From: Martyn White
Sent: 09 April 2019 17:55
To: Planning.Responses
Subject: FW: CM/6/19/HH & CM/7/19/L

CM/6/19/HH & CM/7/19/L

The Climping Mill site comprises a number of buildings which reflect its various past uses including residential, educational, and agricultural. Of note is the main listed Building (Climping Mill), Mil Thatch and Mill Cottage. The application relates to Mill Cottage which sits to the south west of the Mill and is a curtilage listed structure. It is a modest building with an 'angled L-shaped' plan form.

Mill Cottage
Ground Floor Plan
As Proposed

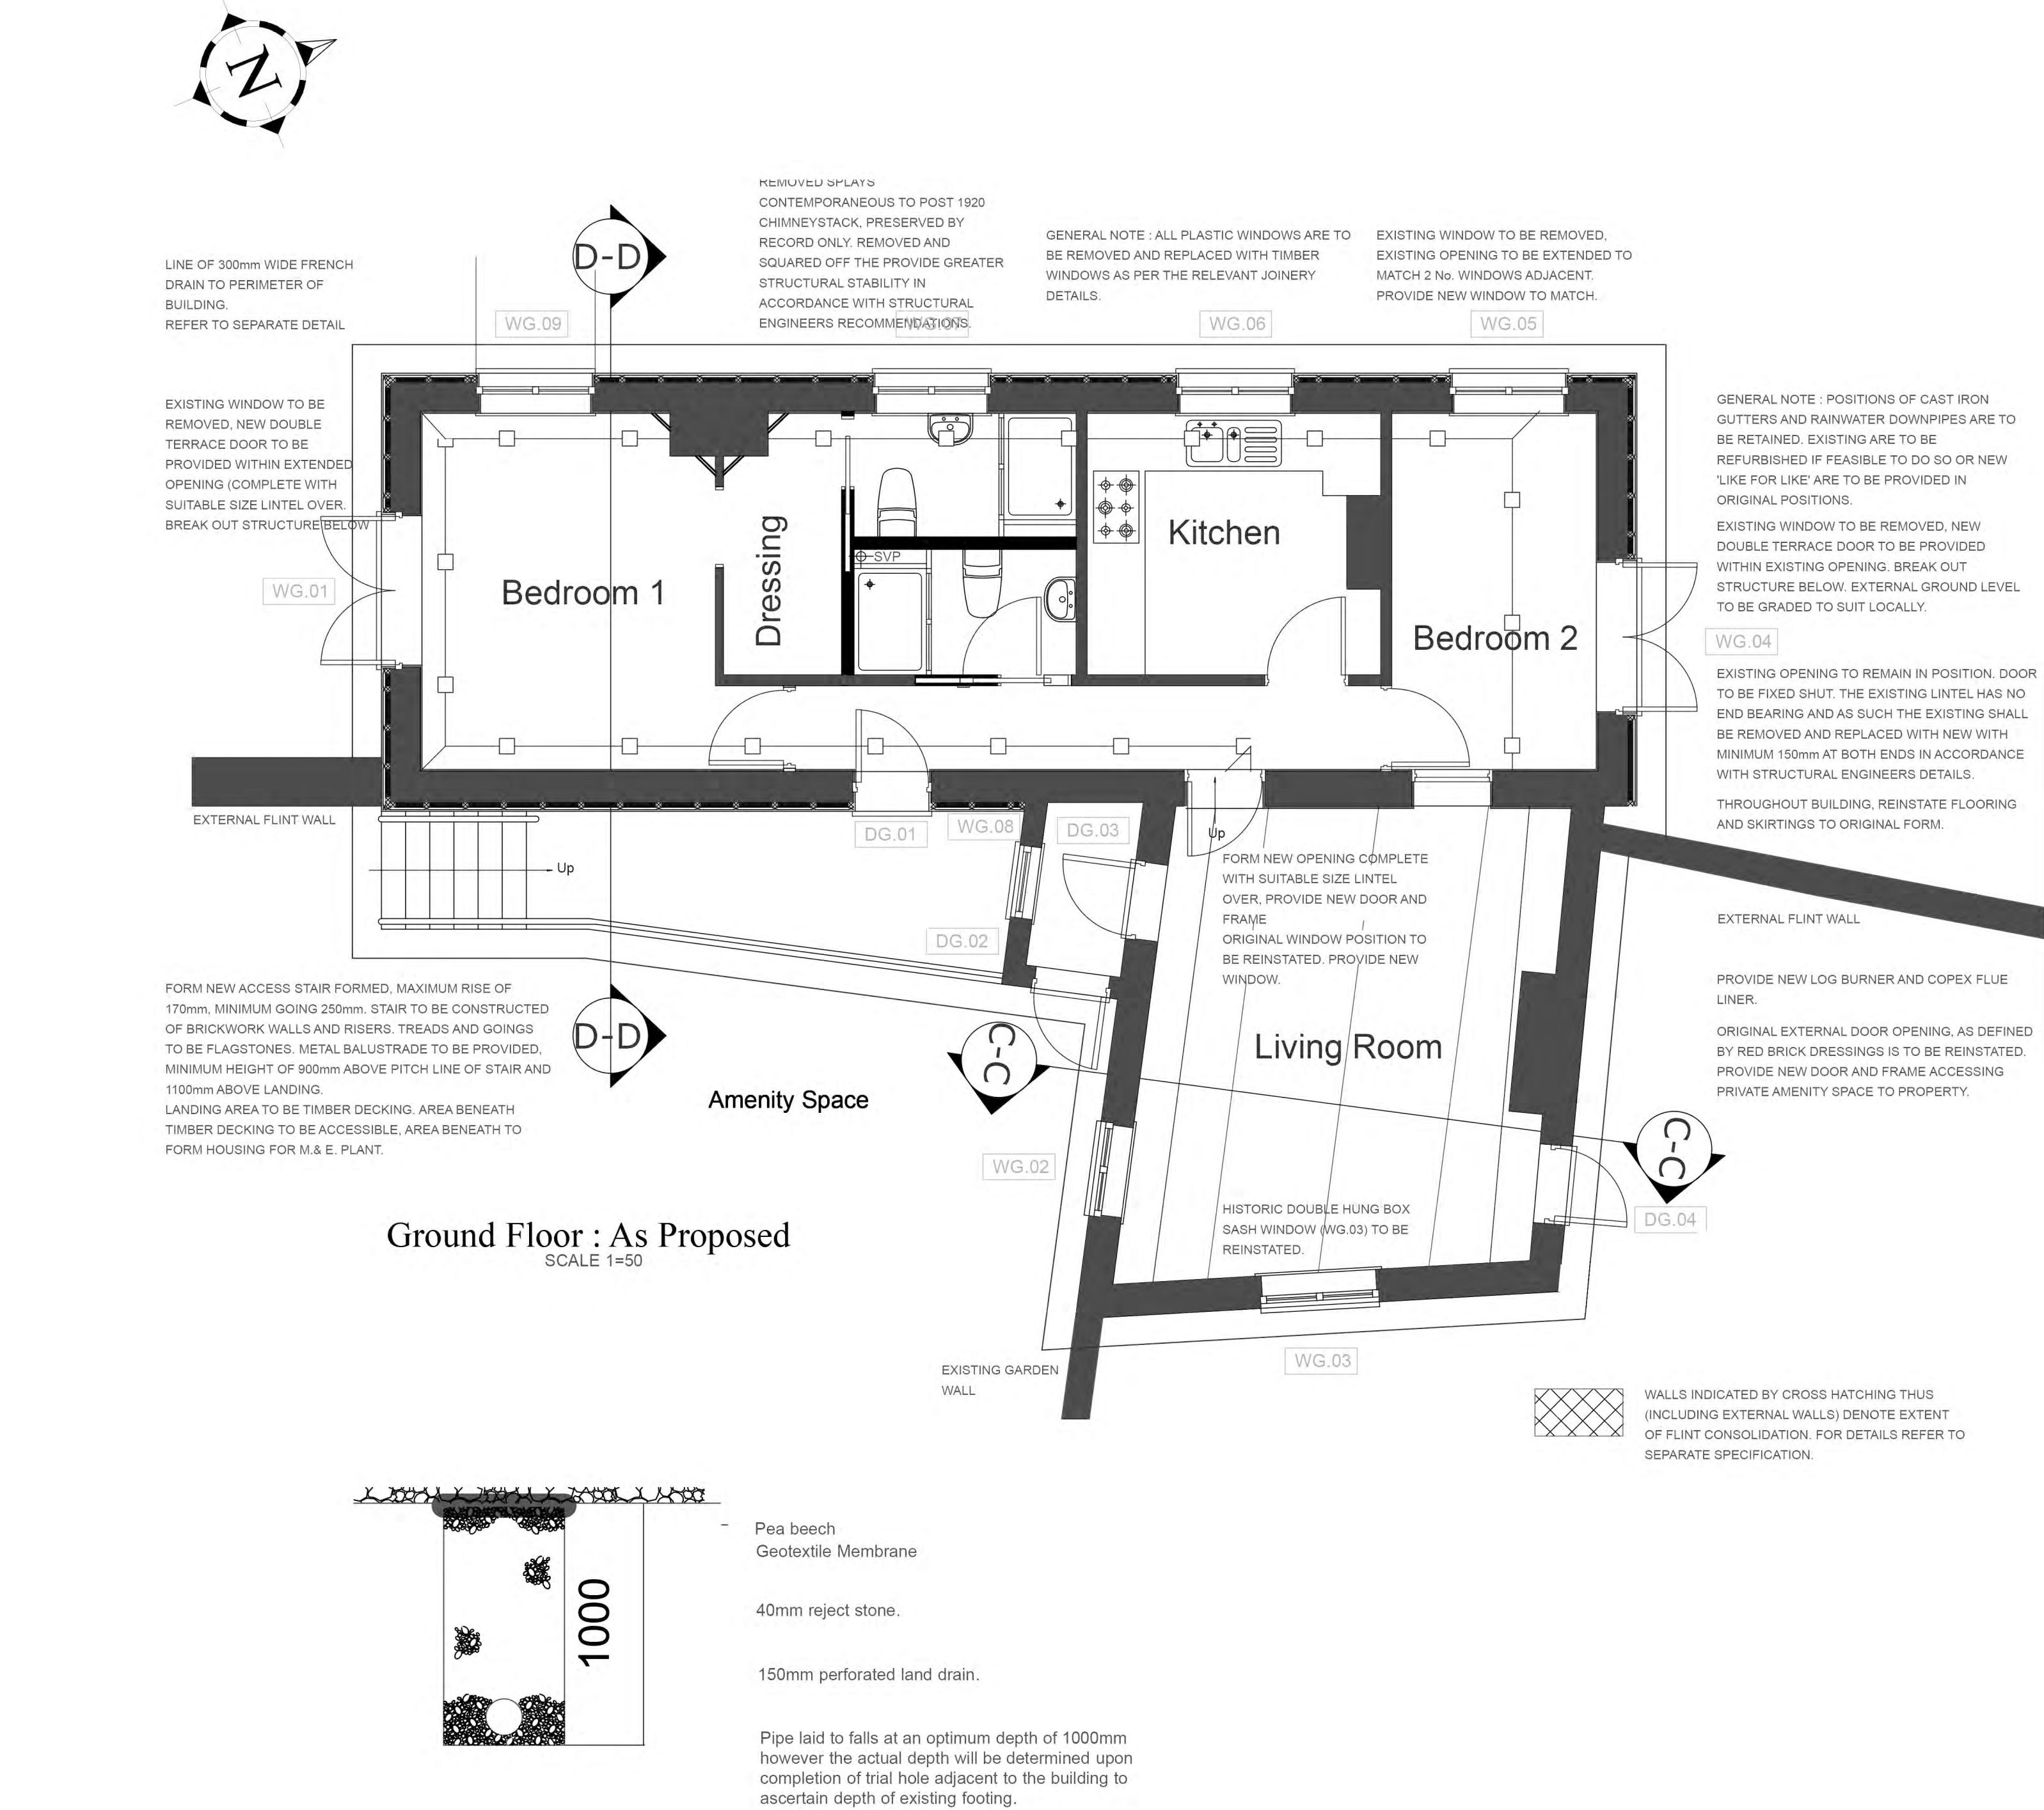
The alteration to the layout of the building is such that it will not harm its character, or result in the loss of any significant amount of historic fabric. Likewise, the loss of what remains of the angular fireplaces will not result in the removal of any significant amount of historic fabric. Such a proposal will allow the internal space to be better used, whilst ensuring that the attractive external chimney can be retained.

Drawing Title
Mill Cottage Elevations As Proposed

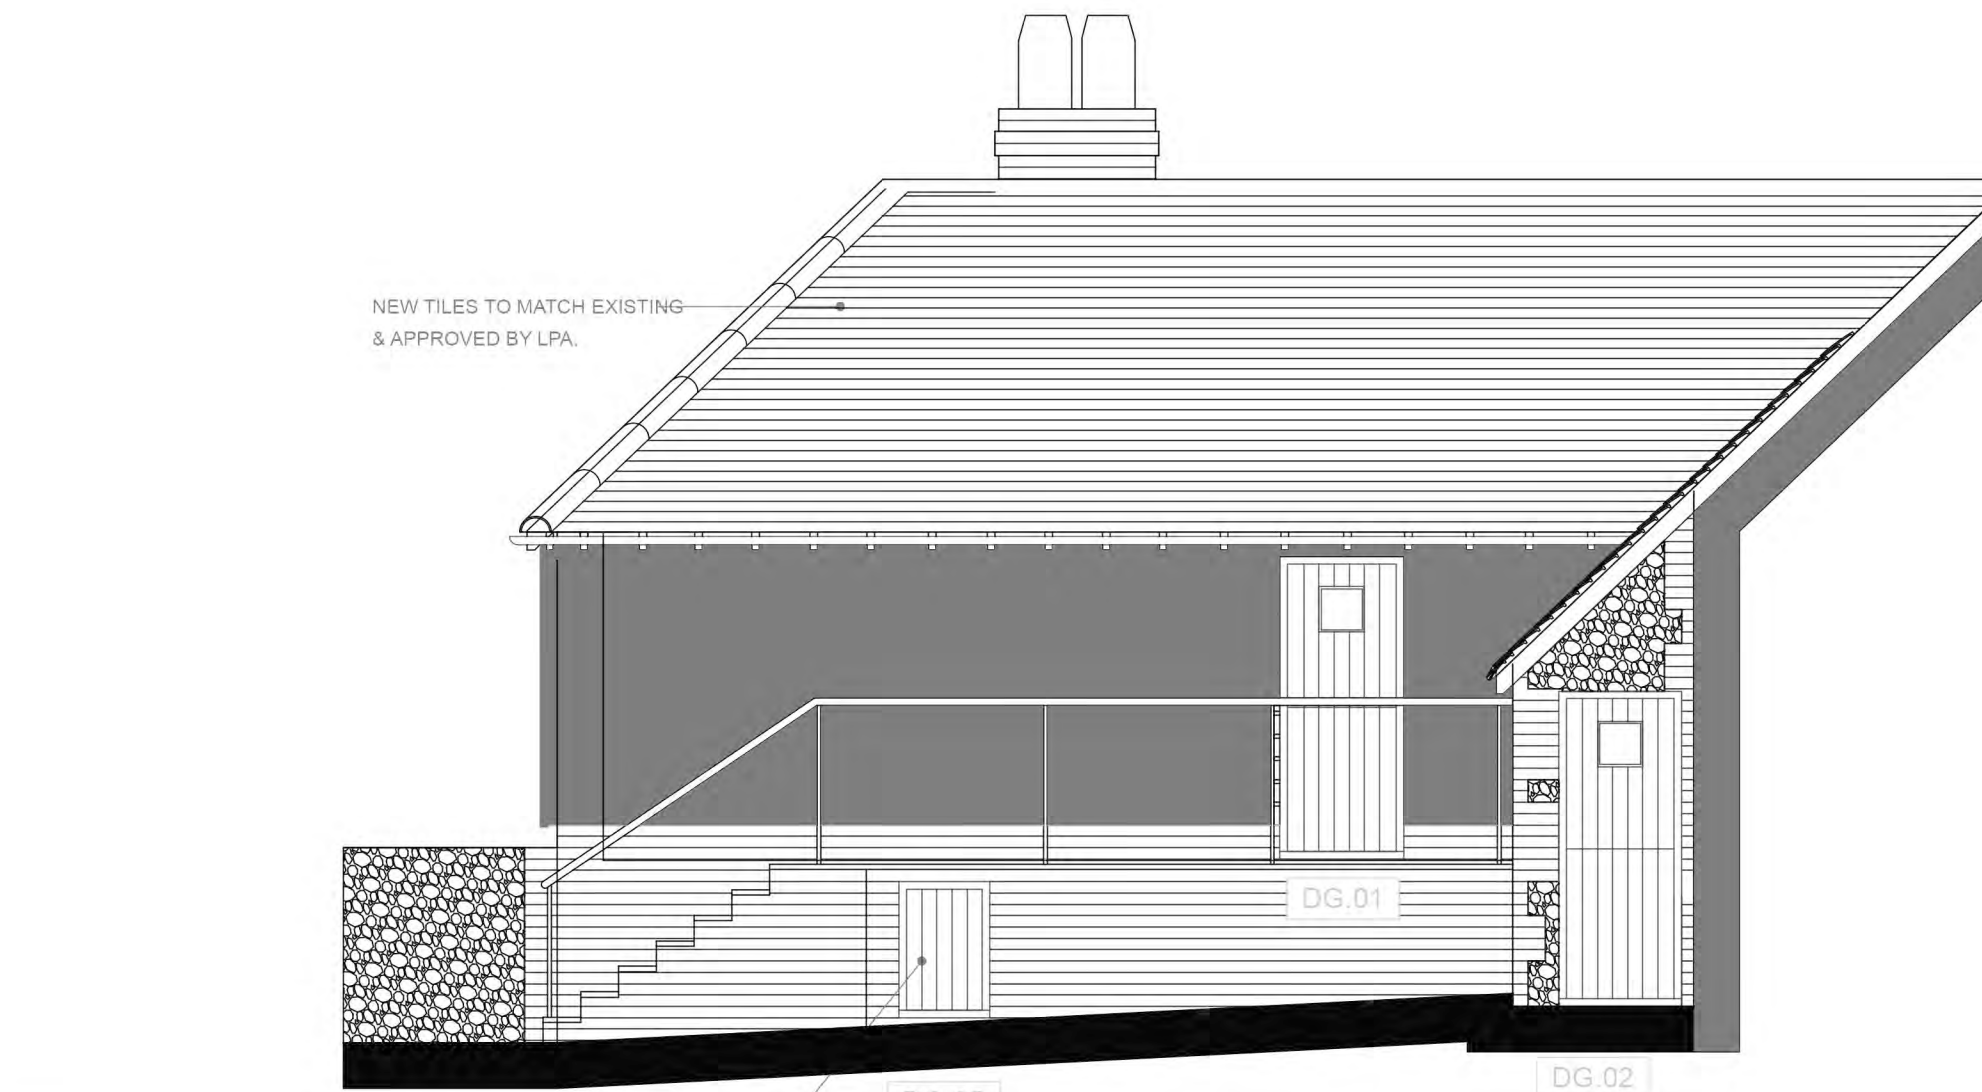
I note that the application seeks to introduce new windows and doors which are more in keeping with the appearance of the property. Such a proposal can be supported, subject to details of their design.

Further, the introduction of additional windows will not harm the character of the building, and their openings will be incorporated into the new cladding proposed. As I am unable to see the details of the windows and doors, they will need to be provided for by way of condition.

The use of the proposed cladding will cover those parts of the building which have the later, more modern brick work. Such a proposal will enable the building to better relate to the main listed building, which bears a similar characteristic.

If minded to approve this application, please provide details of the doors and window by way of condition, as well as details of the decking and the proposed railing. Please also request that the submission of details related to paint/stain colours for the external elevations.
